Our Ref: CSB/NM/E/17066/B5

RE: BILSHAM ROAD, YAPTON

With apologies for the delay in responding, we wanted to reply to your letter dated the 28th August 2014 regarding your refusal of the application to discharge Condition 13 from planning consent Y/48/11/Lamb Inn, Bilsham Road, Yapton, Arundel.

17066-2000 G

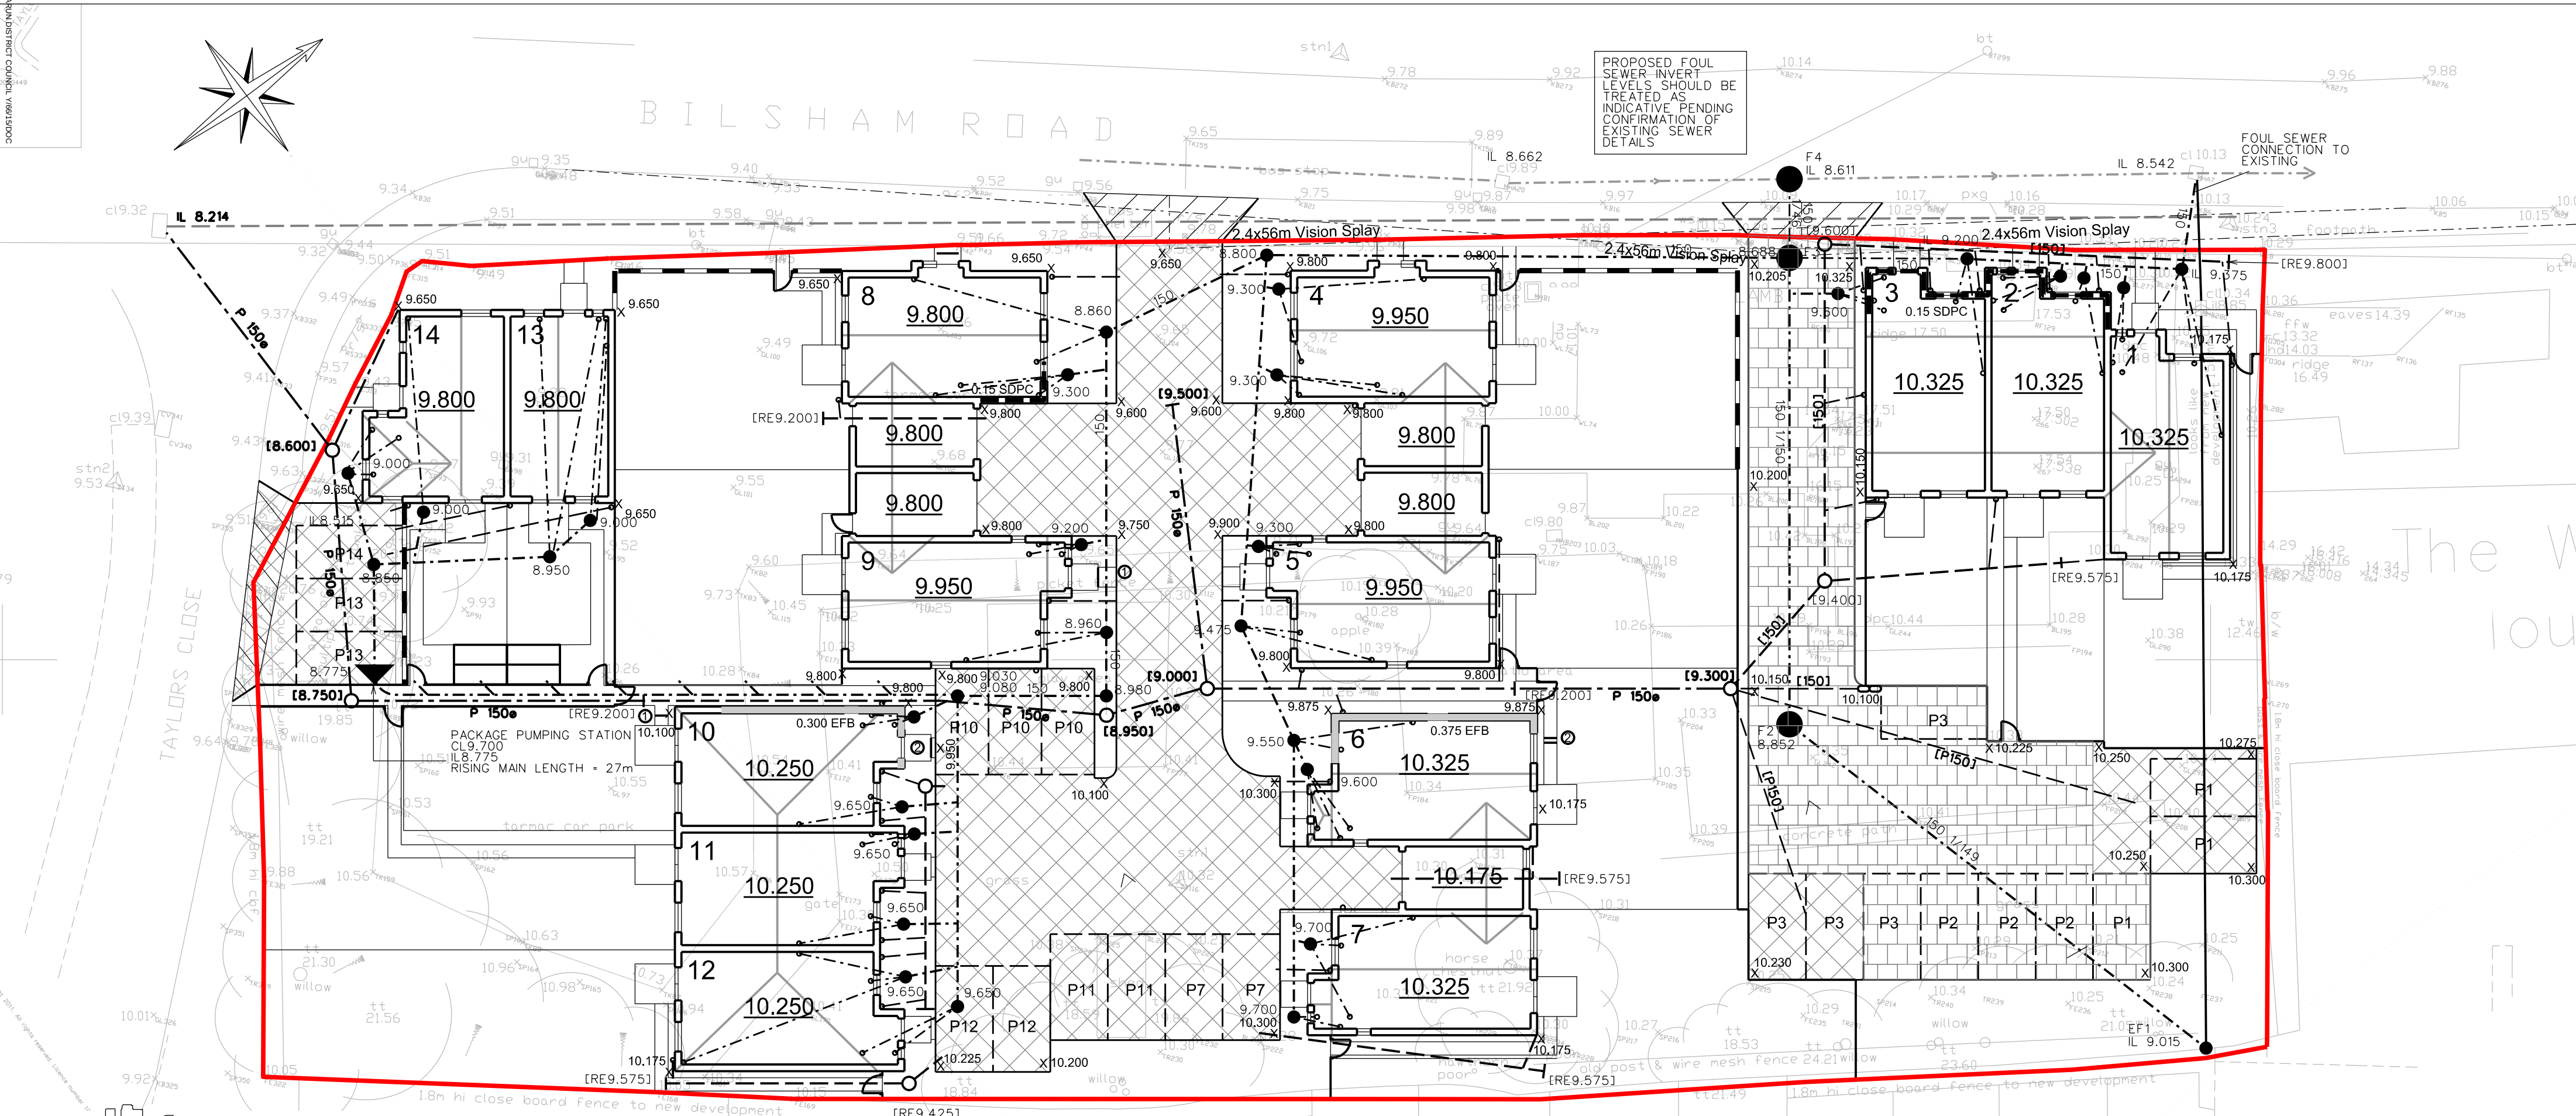
It is our belief that this information together with the accompanying plans and calculations should address your requirements and resolve any outstanding concerns but for the avoidance of doubt we would specifically respond to the bullet point queries in your letter as follows.

1. The ground water on this site has not been encountered at any point through investigation works and we would suggest that this is not surprising bearing in mind the nature of the underlying soils with river terrace gravel deposits lying above chalk. In any event, the proposed drainage facilities which will serve this development will be shallow in nature relying on permeable paving and open voided sub-base material for storage.

2. The calculations which were enclosed have been prepared using microdrainage with a model being set up to incorporate the pipe network and the permeable paving facilities. The discharge for the site is ultimately controlled by way of a hydrobrake and as National Guidance suggests that it is really only practicable to limit outflow to around 5 l/s, you will hopefully be pleased to note that with the low operating head behind the hydrobrake we are actually only looking at a peak discharge of less than 3 l/s for even the 100 year plus climate change rainfall event.

5. The construction drawings which you have requested are attached for your review.
6. We note that Southern Water will not adopt suds or any drainage system which relies on the use of suds for providing attenuation. Accordingly therefore, our Clients propose to keep the drainage system private with the pipe work and the permeable paving being under the control of a management company.

With regard to the query about the connection from the site into the piped watercourse, this was of course originally envisaged in the approved Flood Risk Assessment. Our Clients have located this piped system and have confirmed its invert level and this is reflected in the design drawings.

PRIVATE PARKING COURTS CLOSE GRAGED AGGREGATE ATTENUATION SYSTEM WITH PERMEABLE PAVING CONSTRUCTION

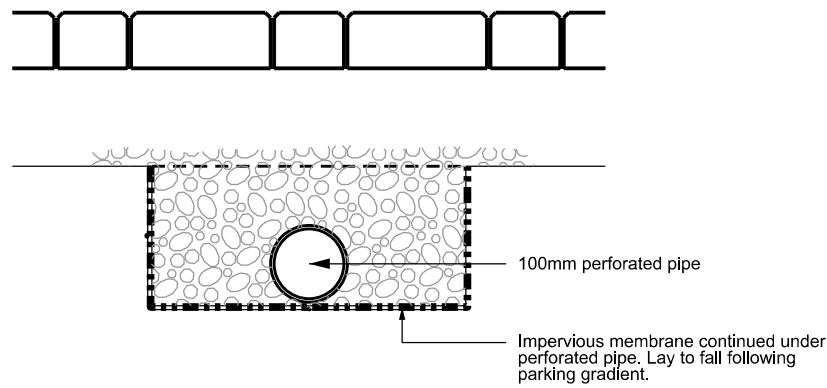
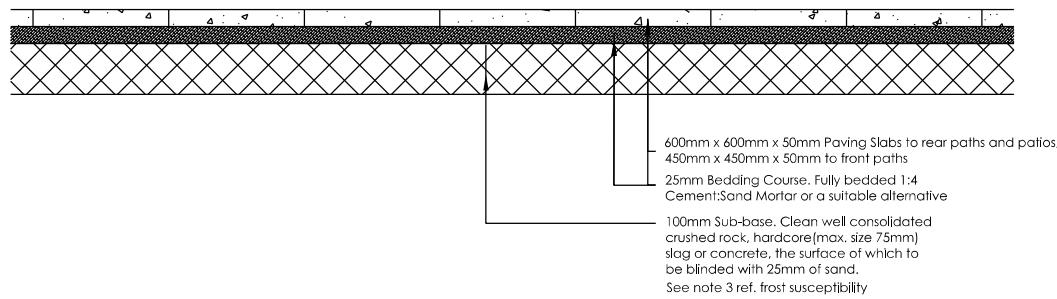
Turning now to the email which our Clients, Matthew Homes, have received from your Mr Tom Callaway dated the 30th June 2015, we would confirm that the underlying open voided sub-base material beneath the porous block paving will have a depth of 600mm. The construction drawing confirming the form of liner and the sub-base specification is attached for your review.

4. The permeable paving will be lined with an impermeable membrane meaning that the underlain permeable subbase will simply act as storage to mitigate the impact of flows downstream.
